Ref: Damansara. 44. Pigeonhouse Lane, Rustington, West Sussex. BN16 2BE

Minor alterations to planning approval: - R/ 11/ 19/ HH

App Ref - R/ 208/ 19/ NMA

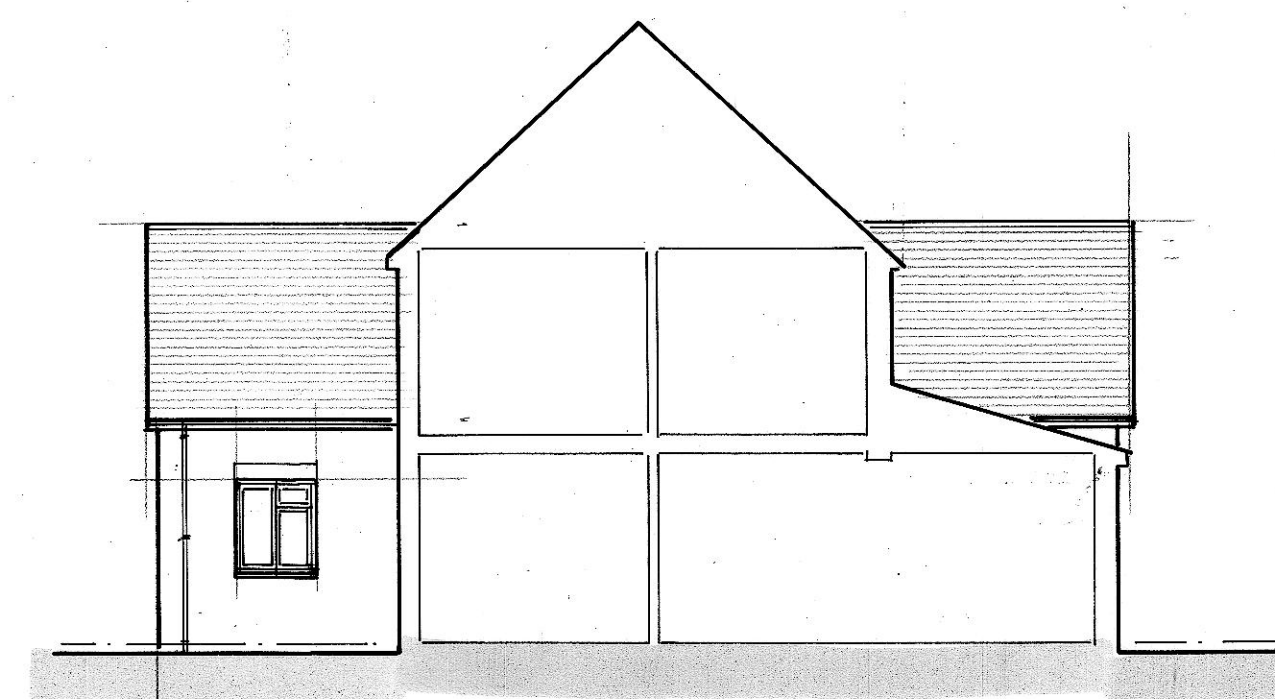
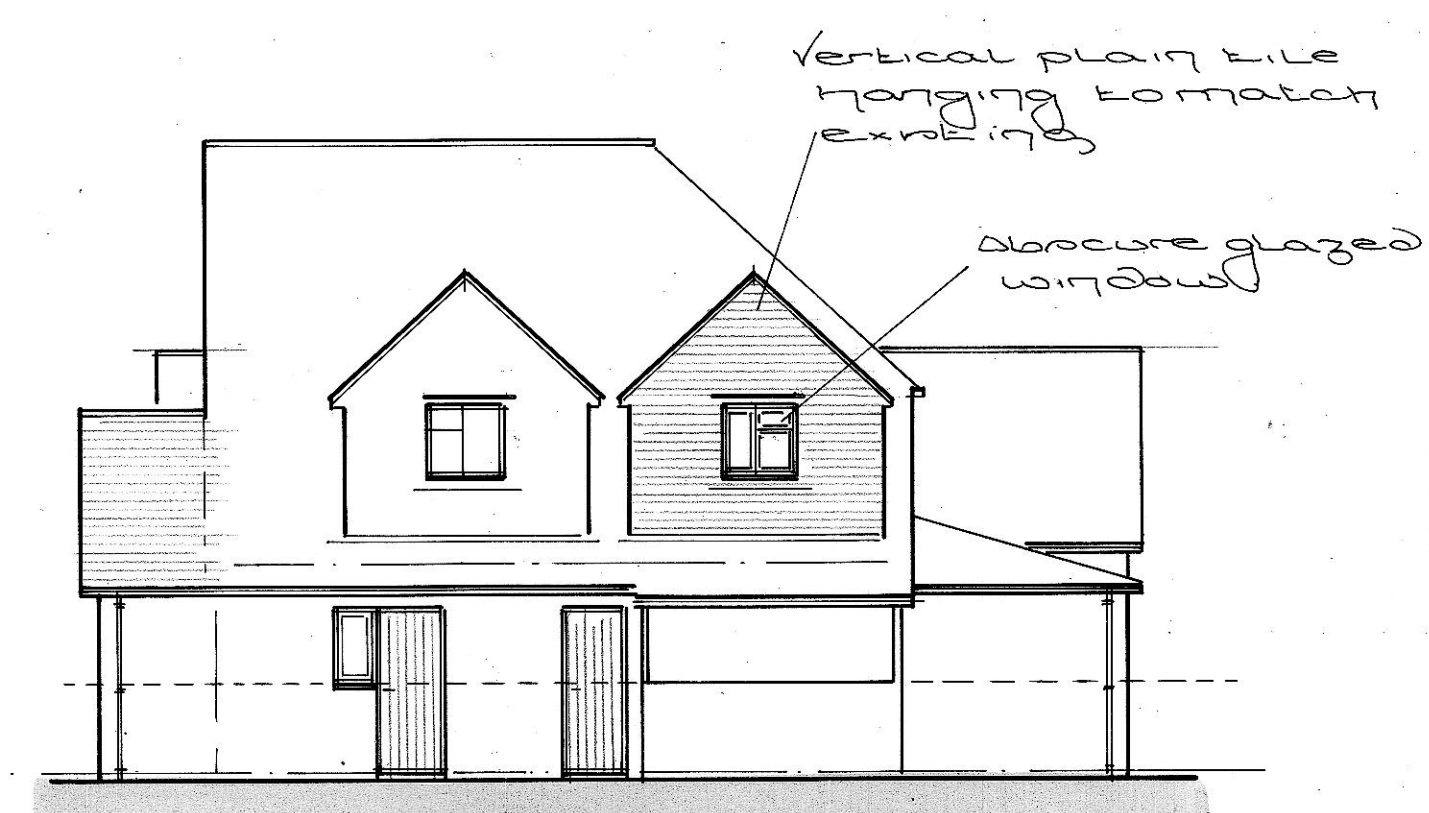
This letter confirms the removal of the additional rooflight and the re positioning of the remaining two roof lights to the exact location on the South elevation as per the original planning approval.
